Recommendation Report for Planning Permission for Works or Extension to a Dwelling

REF NO: EP/4/15/HH

LOCATION: 12 Tamarisk Way
East Preston

PROPOSAL: Proposed extensions & alterations - Resubmission of EP/93/14/HH

DRAWING: SITE PLANS,
SCALE: PROPOSED PLAN, FRONT & SIDE ELEVATIONS
1:1250 1:500
1:50 1:100
DRG No. 1030/6 **DATE:** DECEMBER 2014

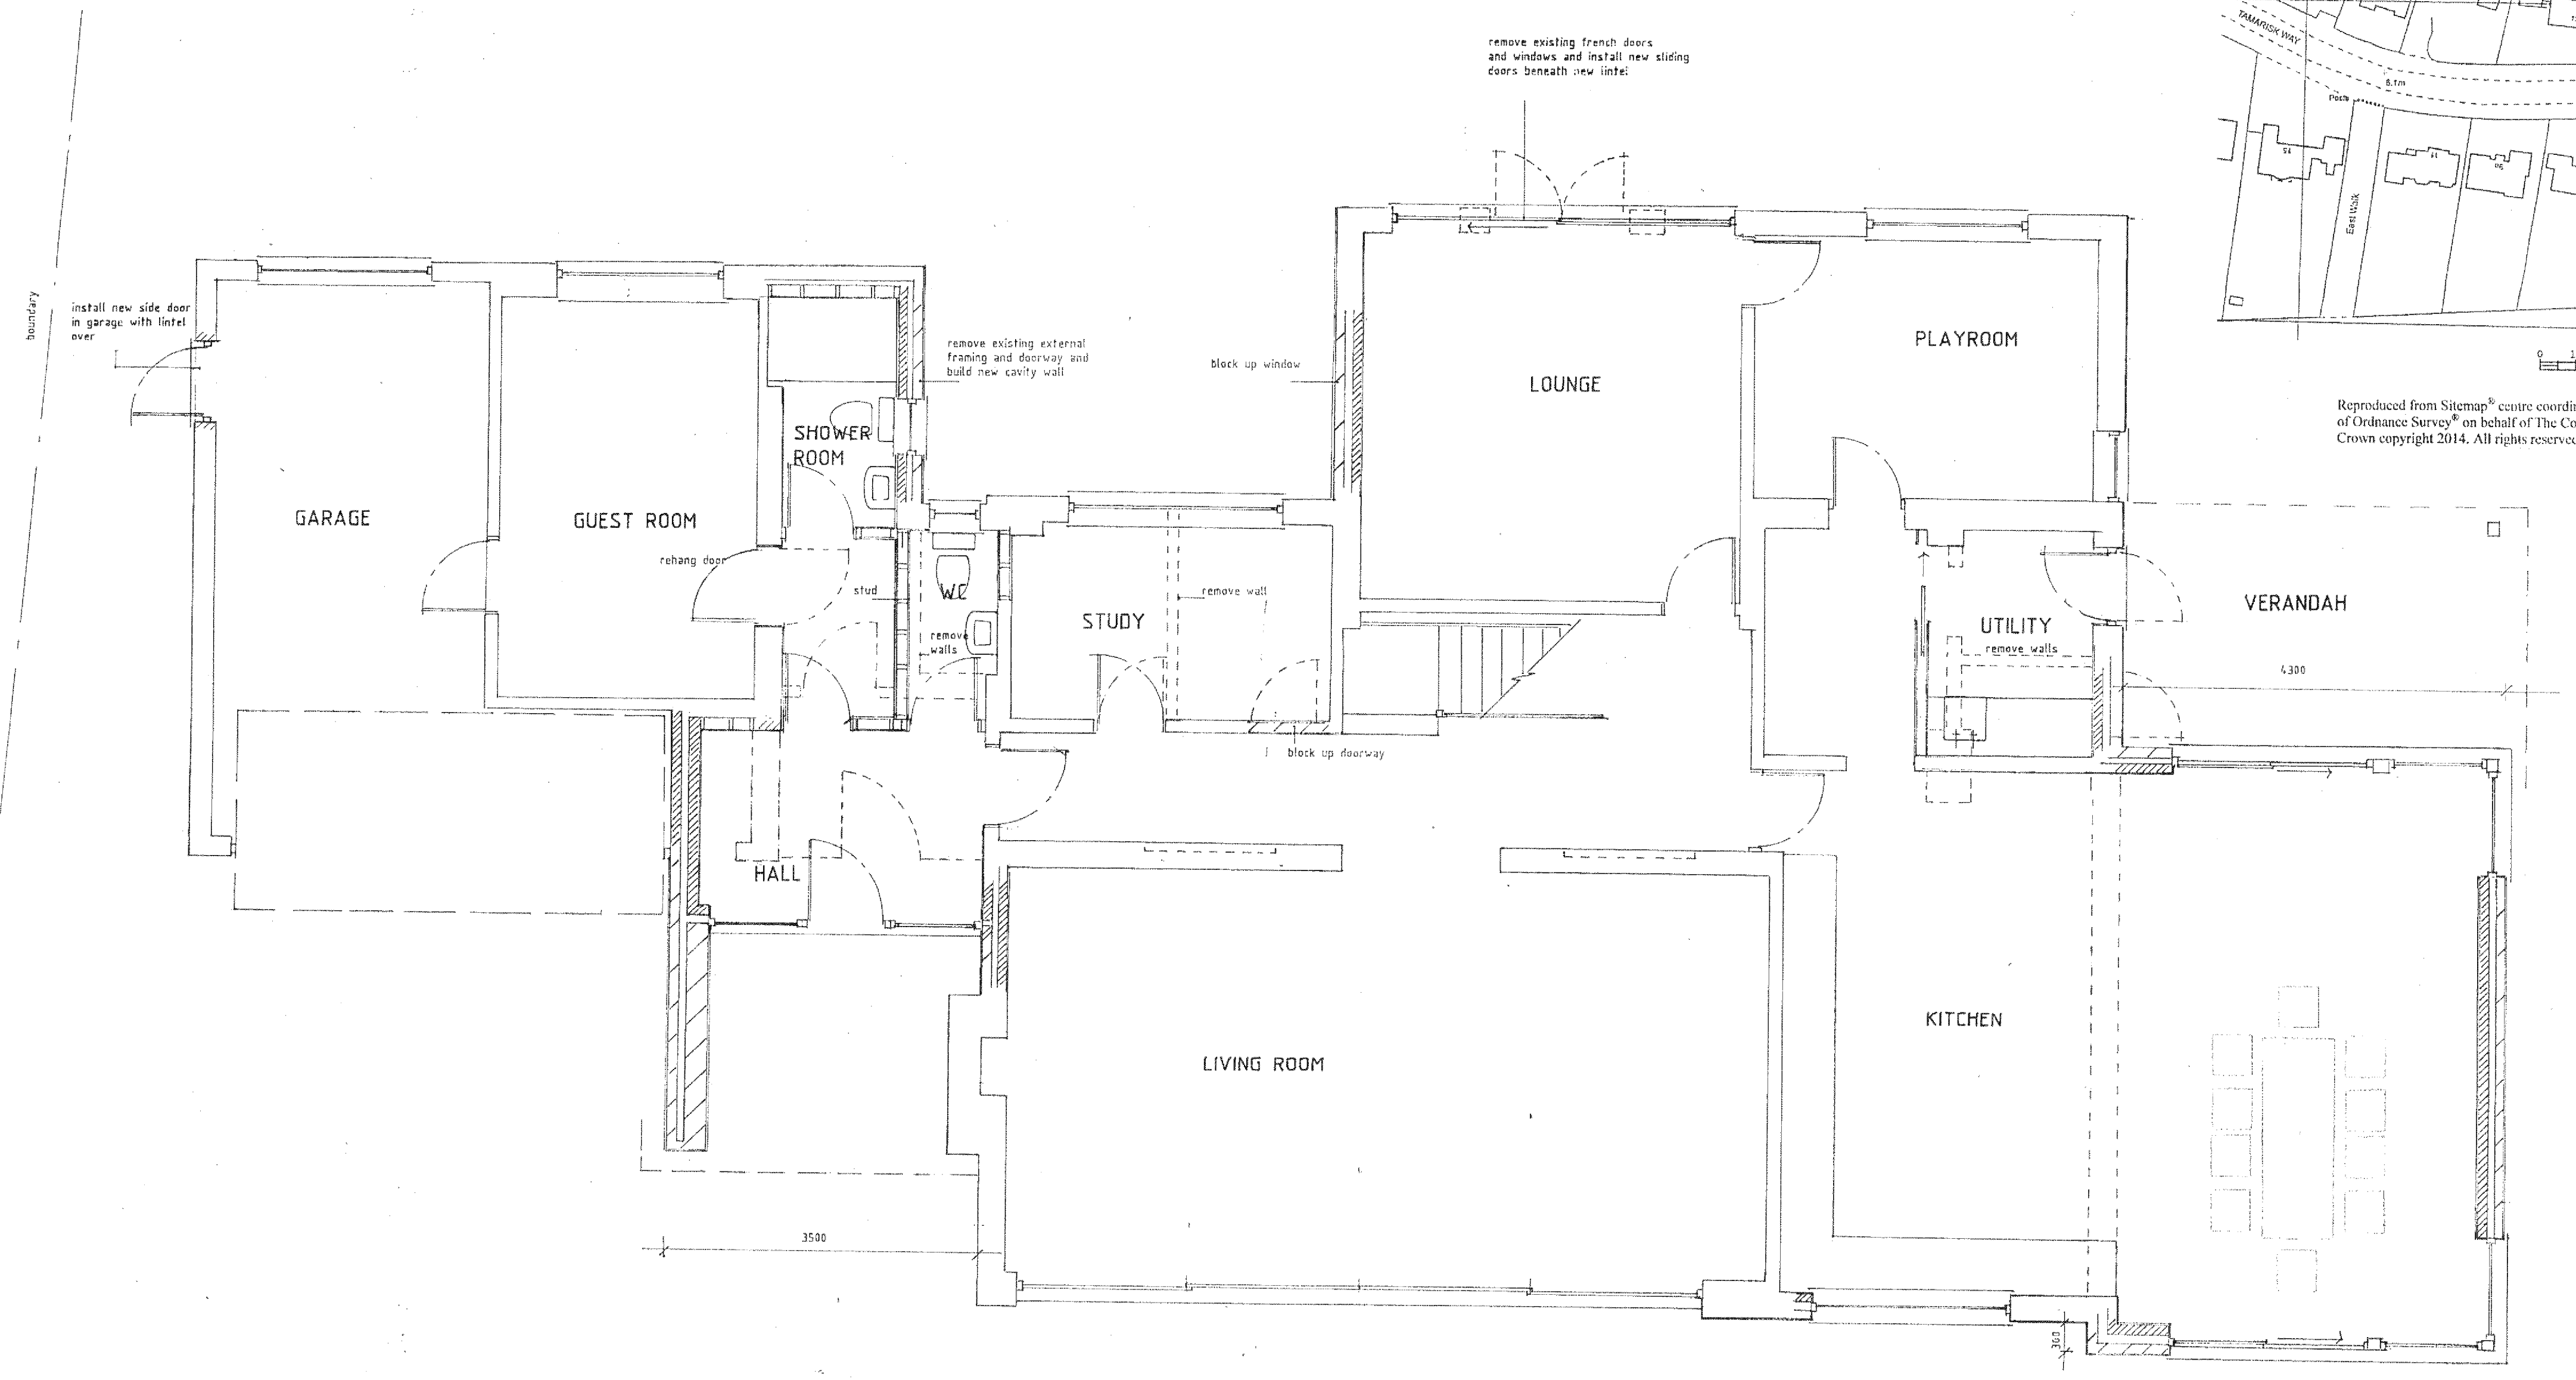
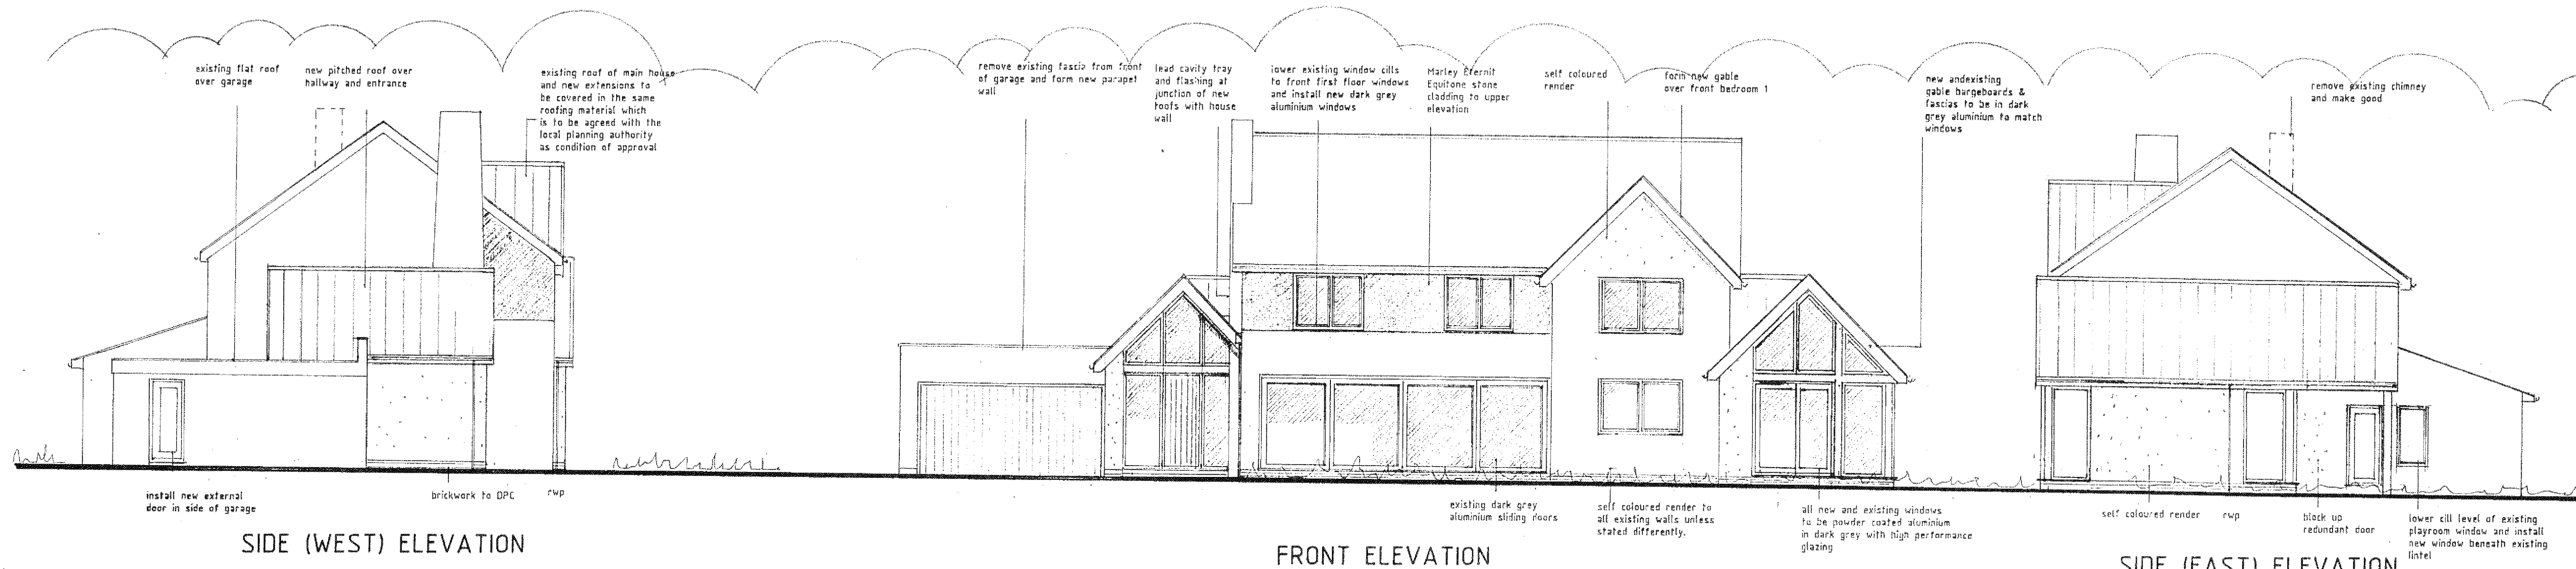
The application seeks permission for the construction of a single storey side extension to the east of the dwelling and a single storey porch extension to the west. It is also proposed that a new gable will be constructed on the primary elevation as well as various alterations to window configurations.

The side extension to the east of the existing dwelling measures 5.5 metres in height and 4.5 metres in width, whilst the proposed porch extension measures approximately 5.3 metres in height and 3.2 metres in width. Both of these extensions are designed to mirror each other in design and as such provide symmetry to the dwelling. The scale and position of the proposed extensions are such that they are deemed to be subservient to the existing dwelling.

The addition of the gable on the primary elevation and the alterations to the existing dwelling and garage are deemed to make a positive contribution to the appearance of the dwelling and is deemed to be in keeping with the existing character of the area.

The proposed works are not deemed to give rise to any adverse impacts upon the residential amenity of adjoining properties. The proposed side extension to the west of the existing dwelling is set back by 7 metres. The eastern side extension is located 2.2 metres from the eastern boundary. Given the eaves height of 2.6 metres this is not deemed to give rise to any adverse overbearing or overshadowing effects upon the neighbouring property. The proposed extensions due to their design and the absence of any additional windows on the side elevations do not give rise to any additional overlooking.
